From: Nicola Spencer on behalf of Planning.Responses
Sent: 12 December 2025 16:24
To: Planning Scanning
Subject: FW: R/215/25/HH

From: [REDACTED]
Sent: 11 December 2025 09:10
To: Breezie Allwright <Breezie.Allwright@arun.gov.uk>
Subject: Re: R/215/25/HH

Drawing:  
**Plans and elevations as proposed**

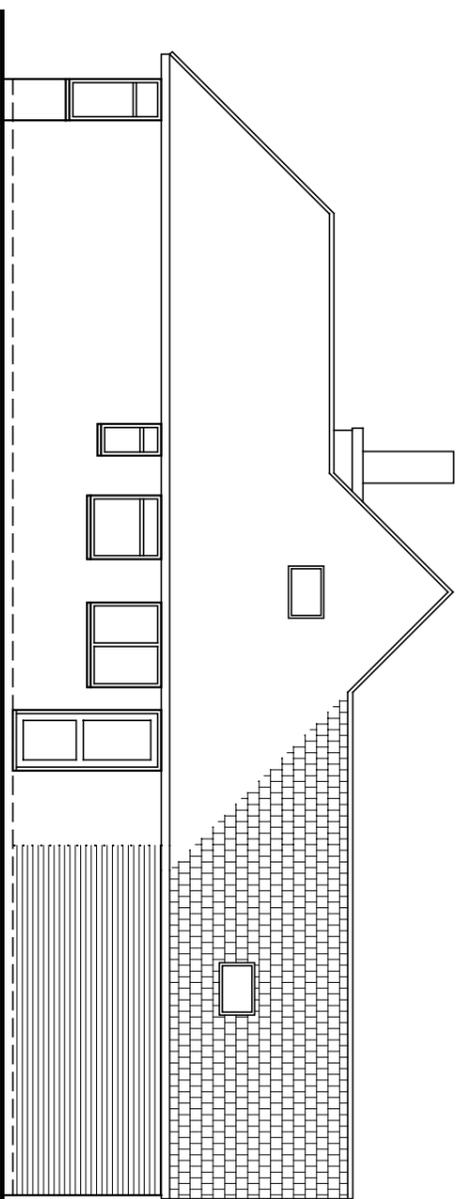
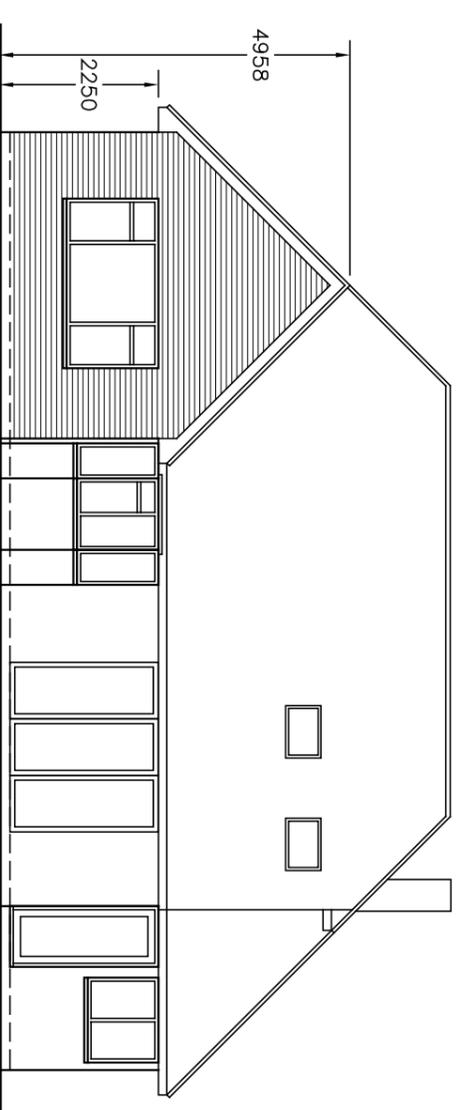
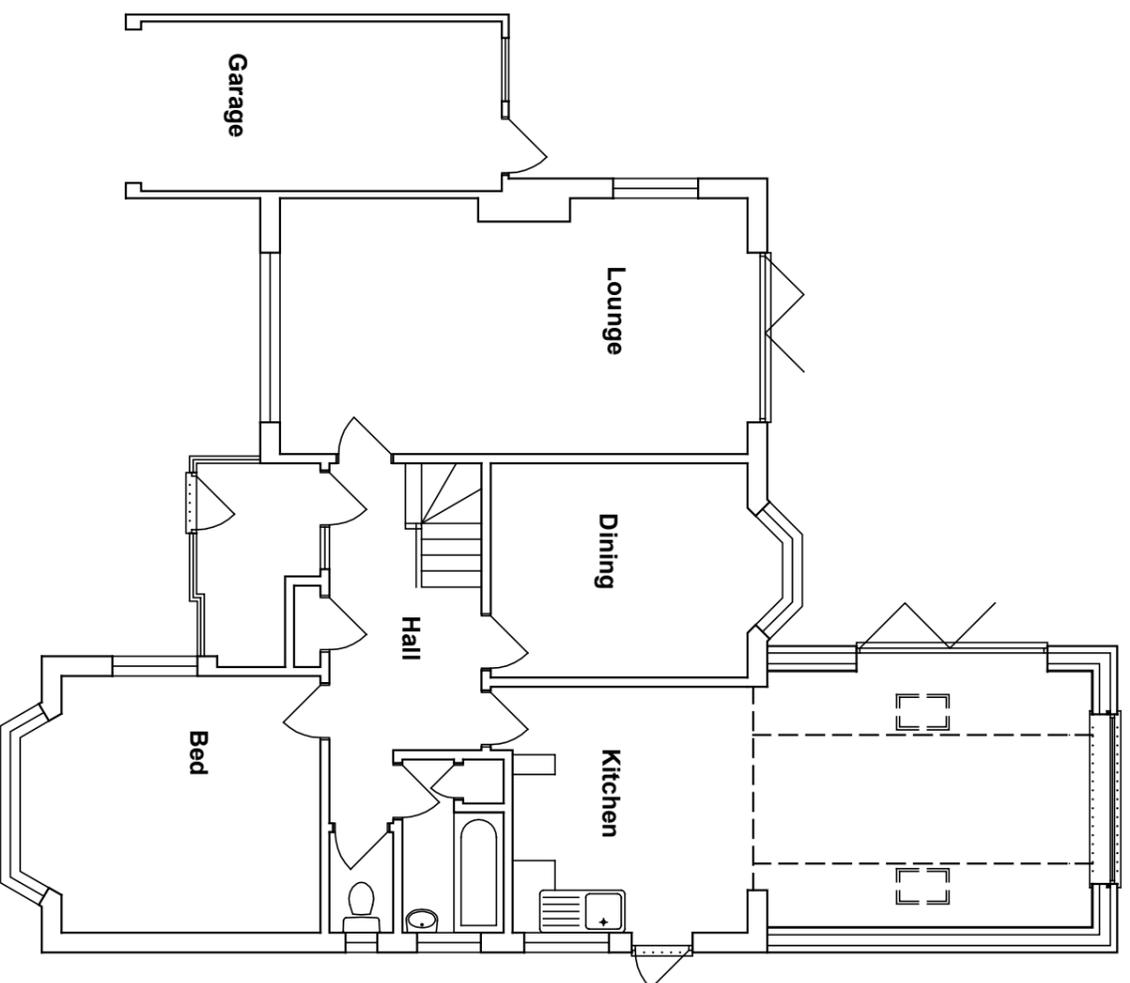
planned extension will block sunlight to main living are and also conservatory,
my south border where light comes from is where thompsons plan to build ,wall and gutter will be high enough to make this occur

Thank you,
i noticed on documents filled in ,asks if their are any trees close to planned extension,
in the boxes it is ticked as a no
This is wrong

yes submitted to you saying no trees or bushes there is not true in falling distance from planned extension,
here are the trees
